As ward councillor I'm making representation by the following comments on behalf of the great many residents of Lavendon who reached out to me in order that their voices be heard.

Title:
Figure 13.22: AIL Routes to Solar and BESS Sites (Sites: Green Hill BESS, F, G)

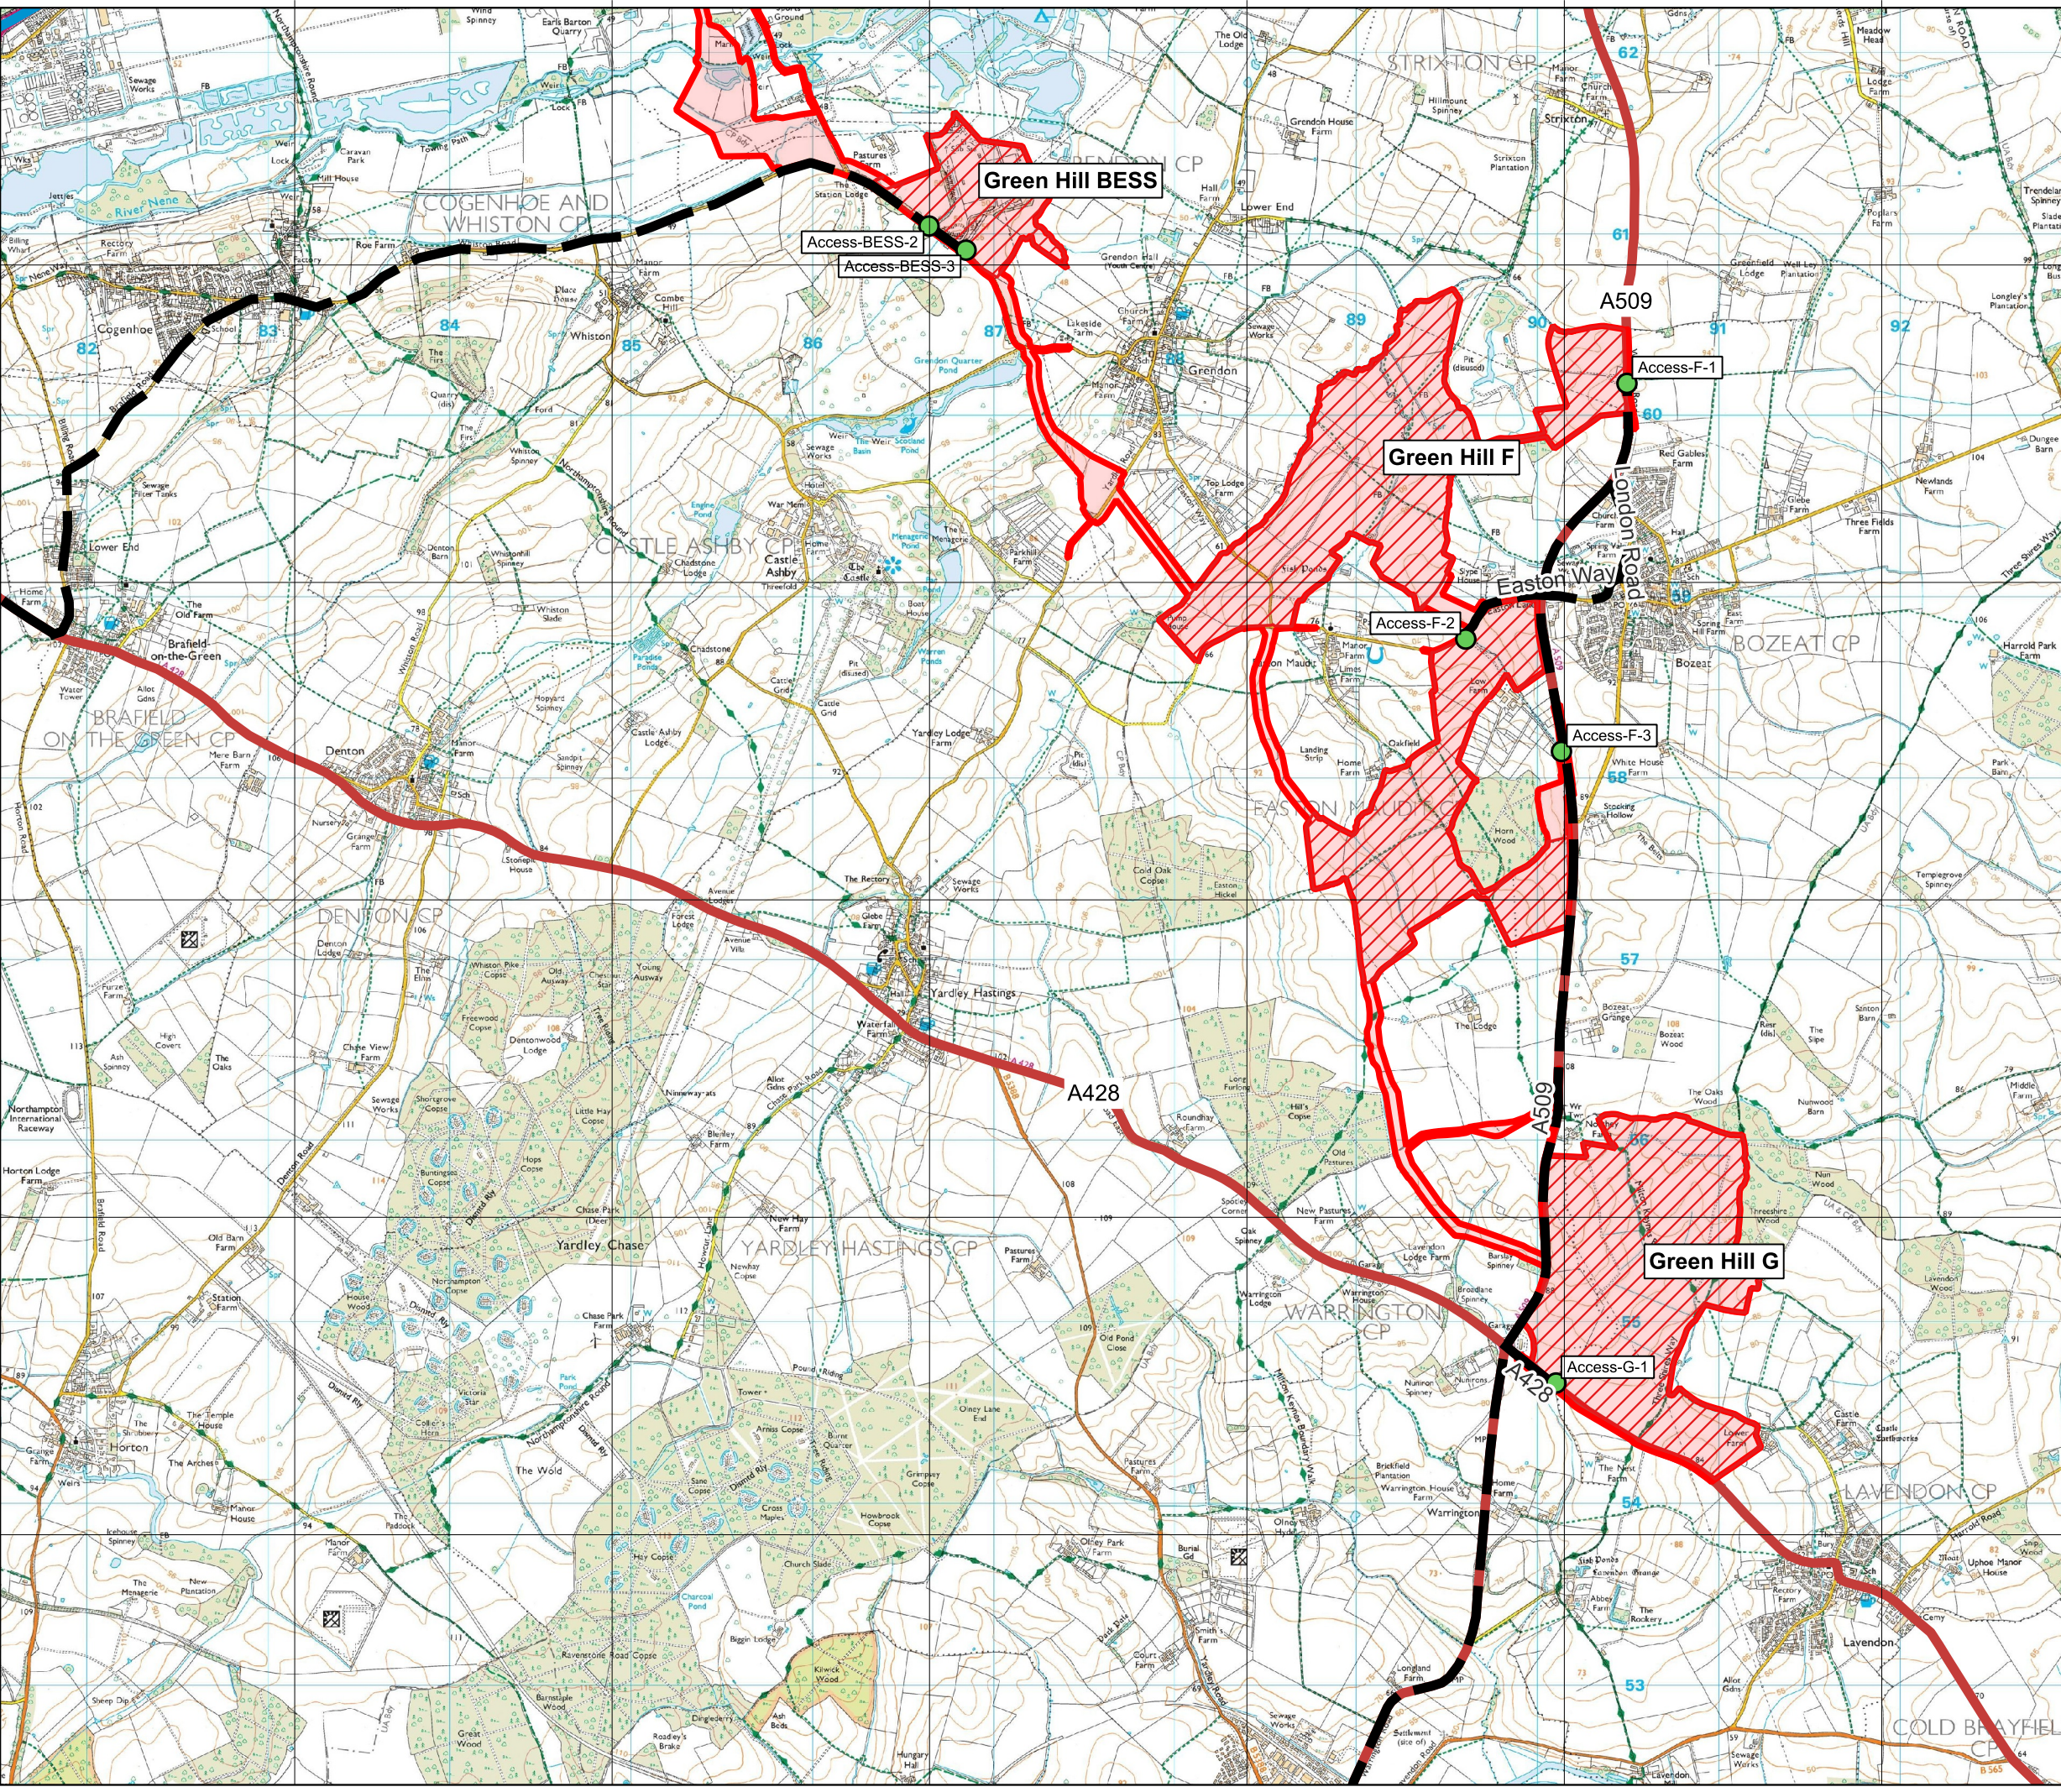
The roads through both Olney and Lavendon will be significant parts of the construction traffic route.

The volume of traffic will increase substantially and the living conditions of residents will be severely impacted, not just by the huge increase in daily traffic, but by the sheer size of some of the construction vehicles: The centre of Olney which is already prone to traffic queues, will be seriously congested. Some of the construction vehicles will be very large loads, which the local roads are simply not designed to accommodate.

The proposed route of construction transport ( using High St Olney ) - a cause for concern by Olney Town Council.. - OTC clerk was assured at a consultation event in May 2024 in Turvey village, Bedfordshire that this would not be the case - therefore understandably deeply concerned and disappointed that these proposals go against something that was stated and concerns raised some 18 months prior.
